Application Reference Number:	2025/0730
--------------------------------------	-----------

Application Type:	Variation of Condition(s)
--------------------------	---------------------------

Proposal Description:	Variation of conditions 2 and 3 of planning application 2021/1303 (Two storey side/rear extension to house)
------------------------------	---

Location:	18 Pack Horse Green, Silkstone, Barnsley, S75 4JT
------------------	---

**PROPOSED SIDE ELEVATION**  
SCALE 1:100

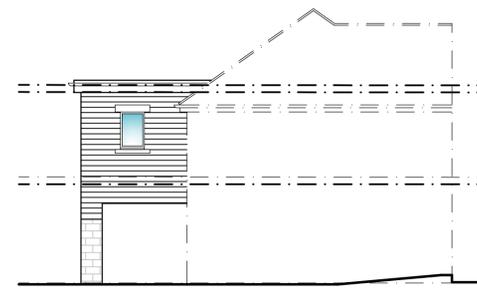
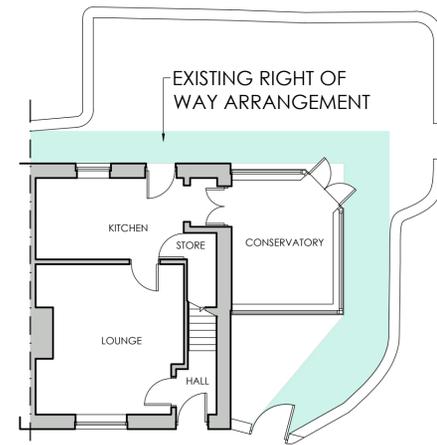
The proposed side extension won't have a significant detrimental impact on any neighbouring property by way of overshadowing or being overbearing as there is no dwelling set to that side of the host dwelling. The impact of overlooking is reduced as the windows have been removed from the side elevation that were previously approved. This weighs significantly in favour of the proposal.

The SPD states that *‘materials should normally be of the same type, colour and texture to the existing house or as close a match as possible’*. In this case, the proposed materials for both extensions will partially match the existing dwelling with matching stonework and roof tiles being used for the front extension and the majority of the front elevation of the side extension. This weighs significantly in favour of the proposal.

The materials changes are to the side and rear however they won't be highly visible in the street scene of Pack Horse Green and although not matching is considered a modern construction material that whilst contrasting would not detract significantly from the character of the dwelling and is instead seen as a complementary feature. This weighs modestly in favour of the proposal.

The SPD states *“all two-storey side extensions should therefore have a pitched roof following the form of the existing roof”*. The side extension has a pitched roof which follows the form of the existing dwelling's hipped roof, is set down from the roof line and partially aligned at the eaves. The side extension also features a flat roof section to the front, whilst not of traditional construction it is not deemed significantly harmful to the street scene as it would only be visible from directly in front of the host dwelling which is set at the end of the street and therefore not highly prominent. The rear extension utilises a pitched roof with a larger flat roof section than previously approved however this change is not deemed significantly harmful.

Also *“to prevent a terracing effect and to avoid detrimental changes to the character of the street scene, it will be desirable to provide a setback of at least 500mm from the main front wall of the dwelling”*. The side extension is significantly setback from the front wall of the dwelling with a distance of over 0.5 metres which is an acceptable setback distance. This weighs significantly in favour of the proposal.

The SPD states that *“the sideways projection of a two-storey side extension should not exceed more than two thirds the width of the original dwelling”* in order to ensure subordination and that the original dwelling stays as the dominant feature. A projection of two thirds the original dwelling is 3.98 metres,

and the proposed projection is less than this at 3.5 metres and therefore acceptable. This weighs significantly in favour of the proposal.

**PROPOSED GROUND FLOOR PLAN**  
SCALE 1:50

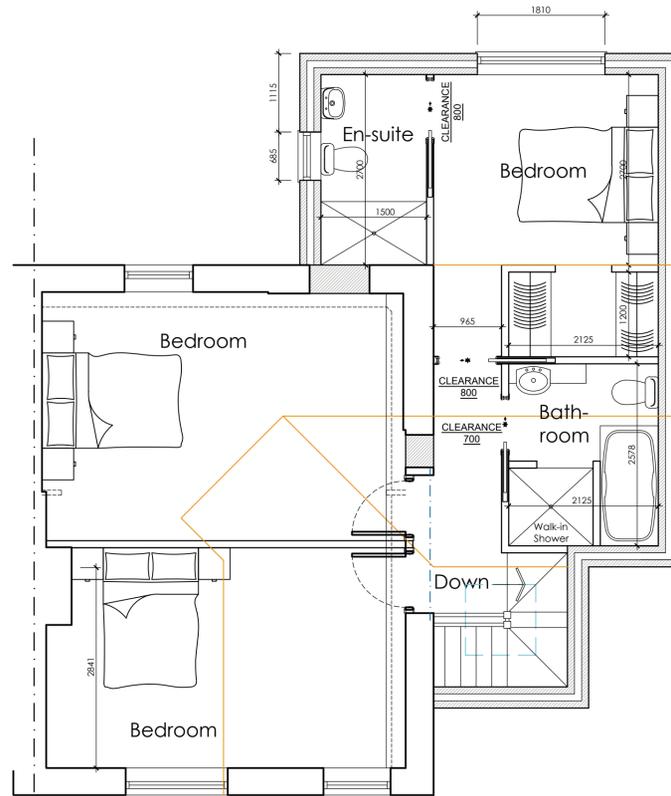
The SPD states *“two-storey rear extensions to semi-detached houses should, therefore, generally be designed with a rear projection of less than 3.5 metres and for terraced houses 2.5 metres”*. Given the host dwelling is an end terraced dwelling it therefore takes the form of a semi-detached dwelling when considering the impact upon neighbouring properties. In light of this the proposed projection of 3 metres is acceptable. There is a window proposed on the side elevation of the rear extension that faces the adjoining property (17 Pack Horse Green), this is to serve an ensuite bathroom and will therefore be conditioned to be obscure glazed to reduce the impact of overlooking. This weighs moderately in favour of the proposal.

The SPD states that *“a distance of 10 metres should normally be provided between rear-facing windows in the first floor (and above) and the rear boundary”*. A distance of 10 metres is partially retained between the rear element of the extension and the rear boundary due to the boundary being set at an angle however the furthest distance is directly behind the proposed siting of the extension which is therefore acceptable. The proposal is considered to be in compliance with Local Plan Policy GD1: General Development and is acceptable in terms of residential amenity. This weighs significantly in favour of the proposal.
